Site plans - building permit

Dominic, Pat, Adam,

CONGRESS STREET NEW CLINICAL TOWER
 Additions and Renovations [PEDESTRIAN ROUTING GIMAN & A STREET]

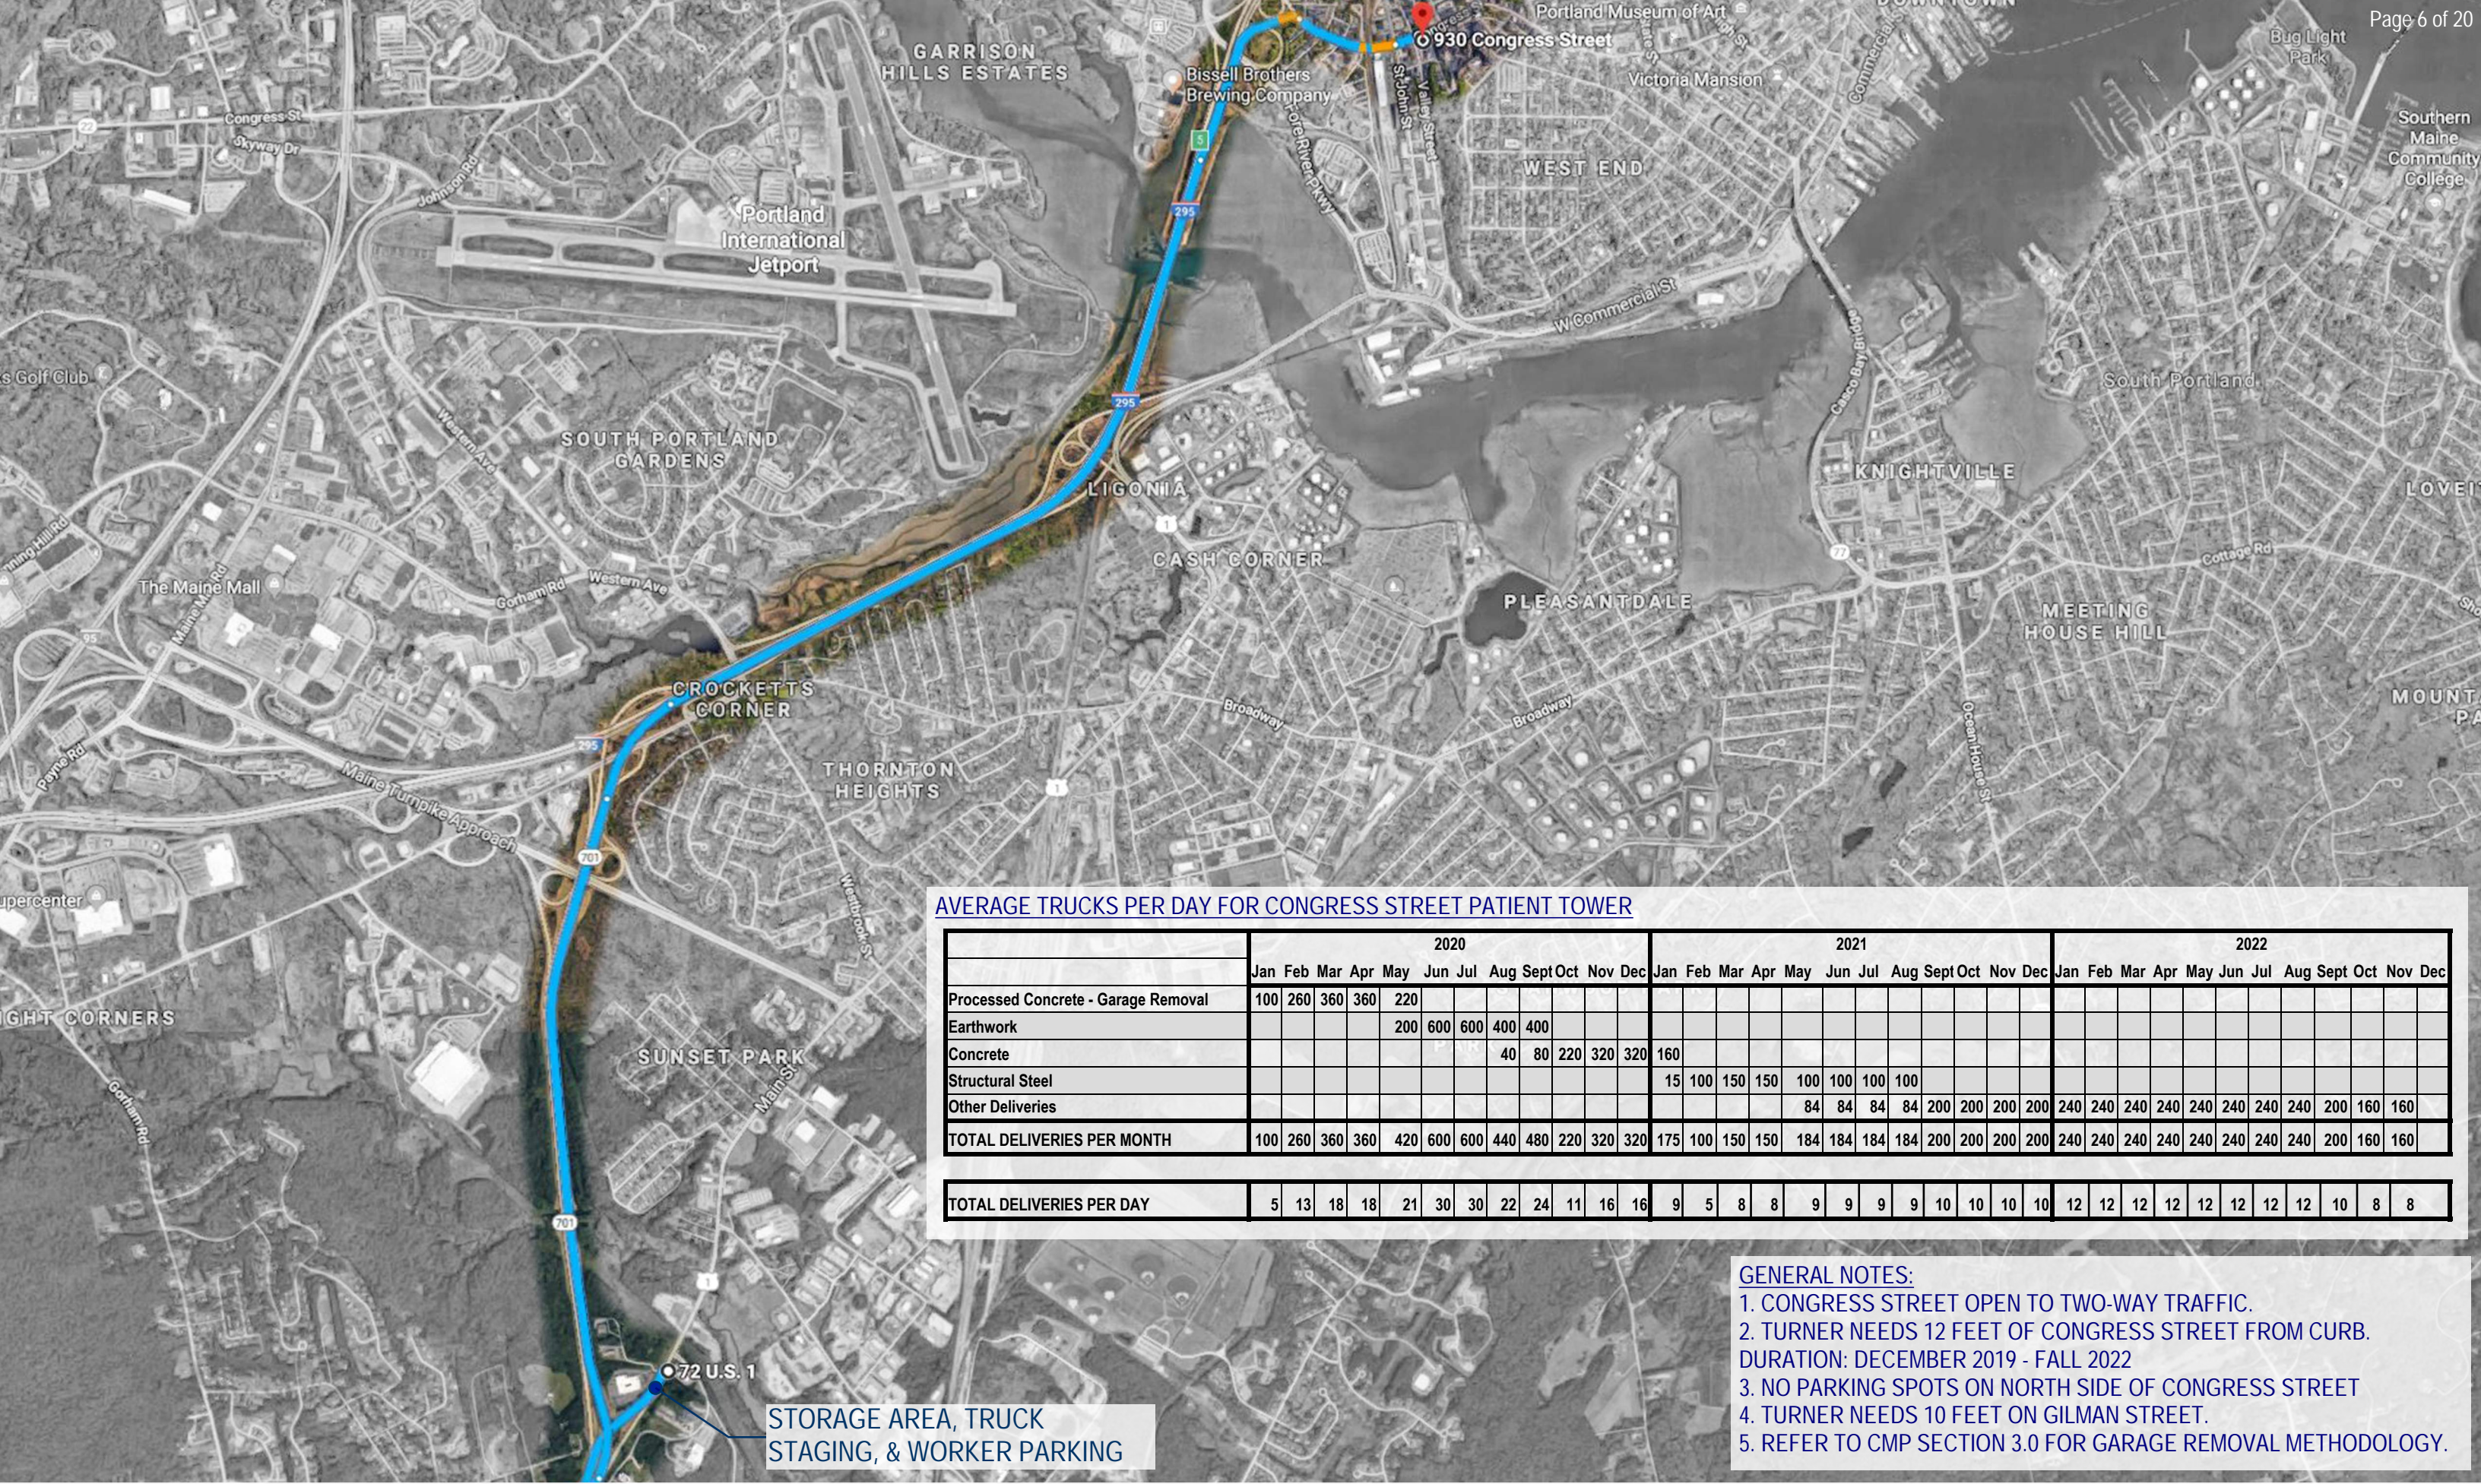
We also have no updated logistics plan since the original CMP submittal in November 2018. There are references to logistics plans in the CMP you've provided here, but no attachments. (See the latest version that we have (not including the package for the enabling work) attached.) Can you provide updated logistics plans if there are any?

It is recommended that further discussion on the duration of the Congress Street sidewalk closures be included. Supplemental pedestrian safety devices will be required during the sidewalk closure time period (to safely cross pedestrians for the sidewalk detour).

All sidewalk detours shall be ADA compliant.

Changes to the lane configuration on Congress Street west of Gilman Street is likely and may need to be included in the plan.
